January 21, 2016

**Re: Catholic Charities**  
**2034 Bridge Blvd., SW**  
**Traffic Circulation Layout**  
Engineer's/Architect's Stamp dated 1-9-16 (L12-D012)

Based upon the information provided in your submittal received 1-20-16, the above referenced plan cannot be approved for Building Permit until the following comments are addressed:

B4 HANDICAP RAMP DETAIL
SCALE: NOT TO SCALE

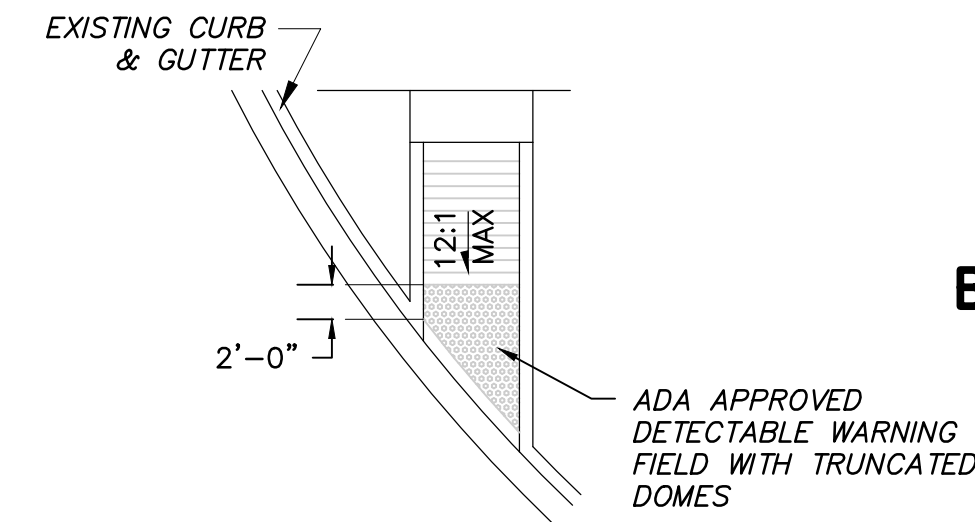
2. Clarify the extents of the current phase.
3. Identify the right of way width, medians, curb cuts, and street widths on Bridge Blvd.
4. Clearly detail sidewalk, curb cuts and handicap ramps along Bridge Blvd.(Key Note #26) Truncated domes are required at handicap ramps in the public right-of-way at curb cuts.

A1 TRAFFIC CIRCULATION LAYOUT AND SITE DIMENSION PLAN

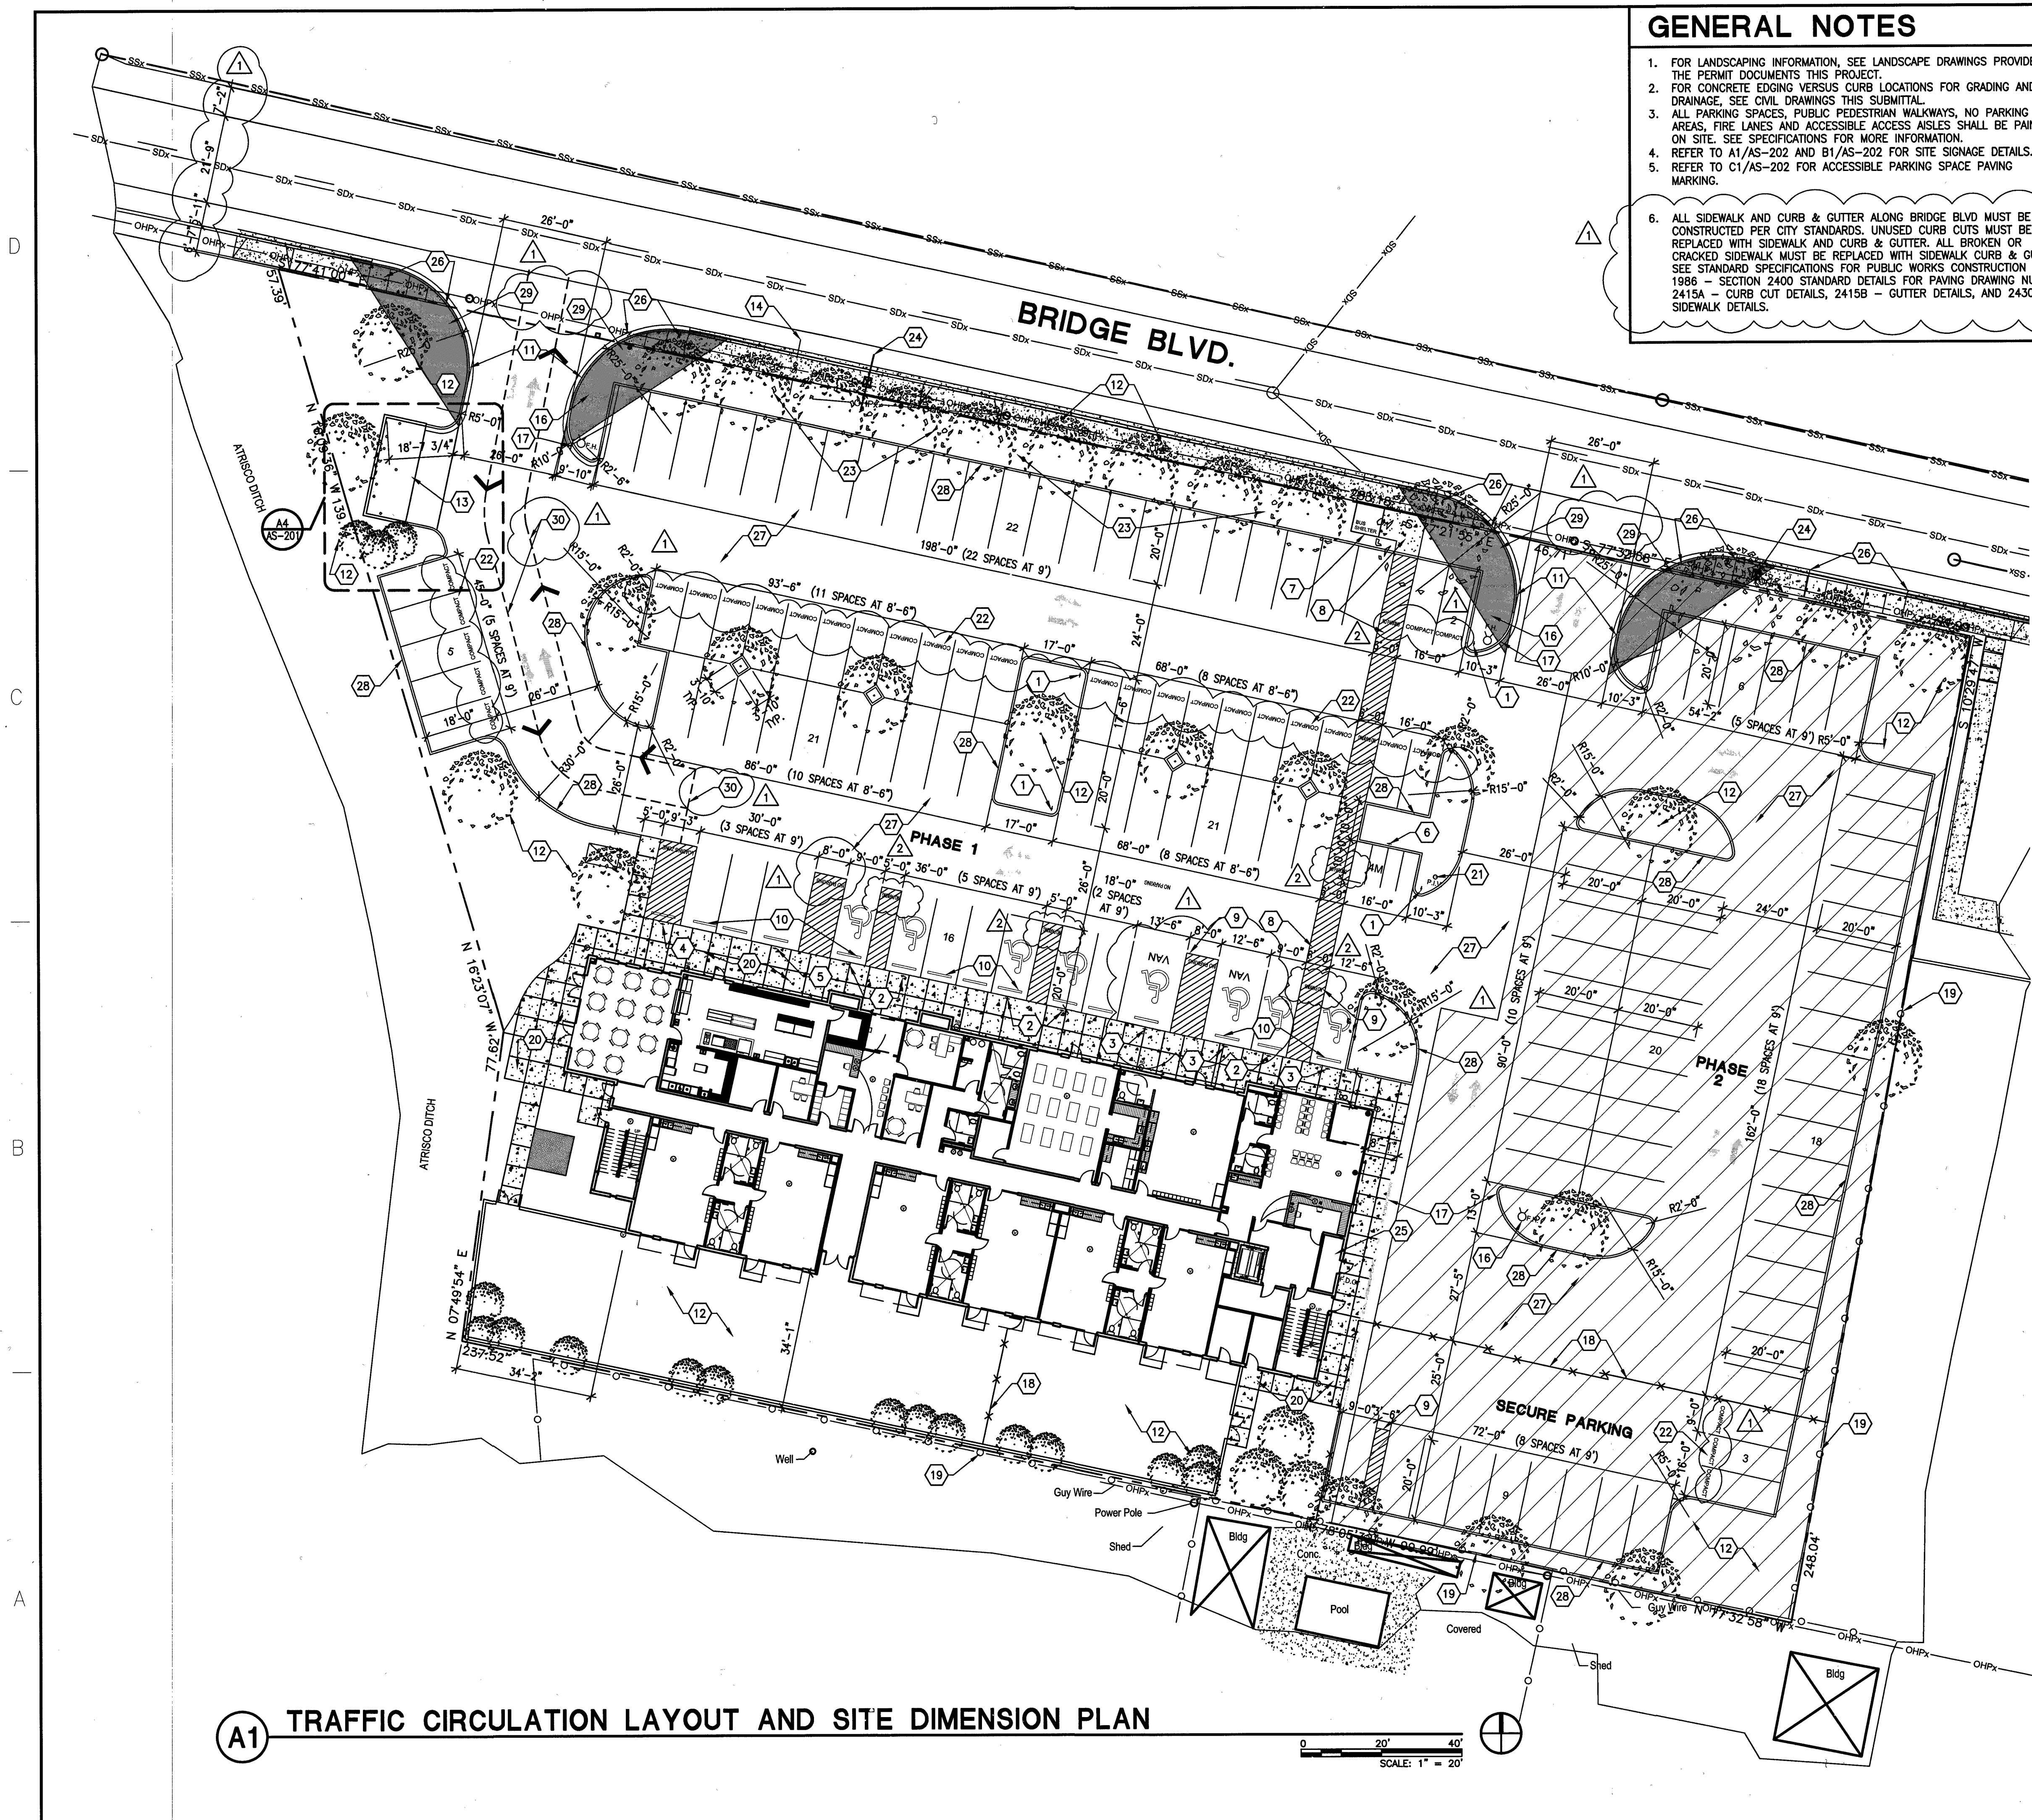
1. Please show a vicinity map showing the location of the development in relation to streets and well known landmarks. Please clearly show the lots proposed in the project.

5. The handicap accessible spaces must include an 8-foot wide van access aisle; all other aisles should be 5 feet in width. In review of submitted drawing the access isle are shown to be 3.5 ft. in width(Key Note #9).

6. Per provided parking calculations, the site requires two ADA van accessible parking spaces with accessible isles. Please reconfigure parking spaces to accommodate the required van accessible parking spaces.

7. The ADA accessible parking sign must have the required language per 66-7-352.4C NMSA 1978 **"Violators Are Subject to a Fine and/or Towing."**
8. The ADA access aisle shall have the words **"NO PARKING"** in capital letters, each of which shall be at least one foot high and at least two inches wide, placed at the rear of the parking space so as to be close to where an adjacent vehicle's rear tire would be placed. (66-1-4.1.B NMSA 1978)

9. Per the DPM, a 6 ft. wide ADA accessible pedestrian pathway is required from the HC parking stall access aisles to the building entrances. Please clearly show and dimension this pedestrian pathway from the ADA parking space on the south side of proposed building to the building entrance.

10. Label the compact parking spaces by placing the words “**COMPACT**” on the pavement of each space.
11. Provide a min 6" or max 8" high concrete barrier curb or other acceptable barrier between landscaping and parking areas and/or drive aisles. Please call out the dimension of the proposed concrete barrier curb.
12. Design delivery vehicle route needs to be shown.
13. Service vehicle and/or refuse vehicle maneuvering must be contained on-site; provide a copy of refuse approval.
14. It is not apparent what type of pavement surface is being proposed. A hard driving surface will be required as part of this proposed project for parking area and drive aisles.
15. Please provide a sight distance exhibit (see the *Development Process Manual, Chapter 23, Section 3, Part D.5 Intersection Sight Distance*). Please call out this detail for both entrances/exits off of Bridge Blvd.

16. Please add the following note to the clear sight triangle: “Landscaping and signage will not interfere with clear sight requirements. Therefore, signs, walls, trees, and shrubbery between 3 and 8 feet tall (as measured from the gutter pan) will not be acceptable in this area.”
17. Unused curb cuts must be replaced with sidewalk and curb & gutter. A build note must be provided referring to the appropriate City Standard drawing.
18. All broken or cracked sidewalk must be replaced with sidewalk and curb & gutter. A build note must be provided referring to the appropriate City Standard drawing.
19. Please include two copies of the traffic circulation layout at the next submittal.
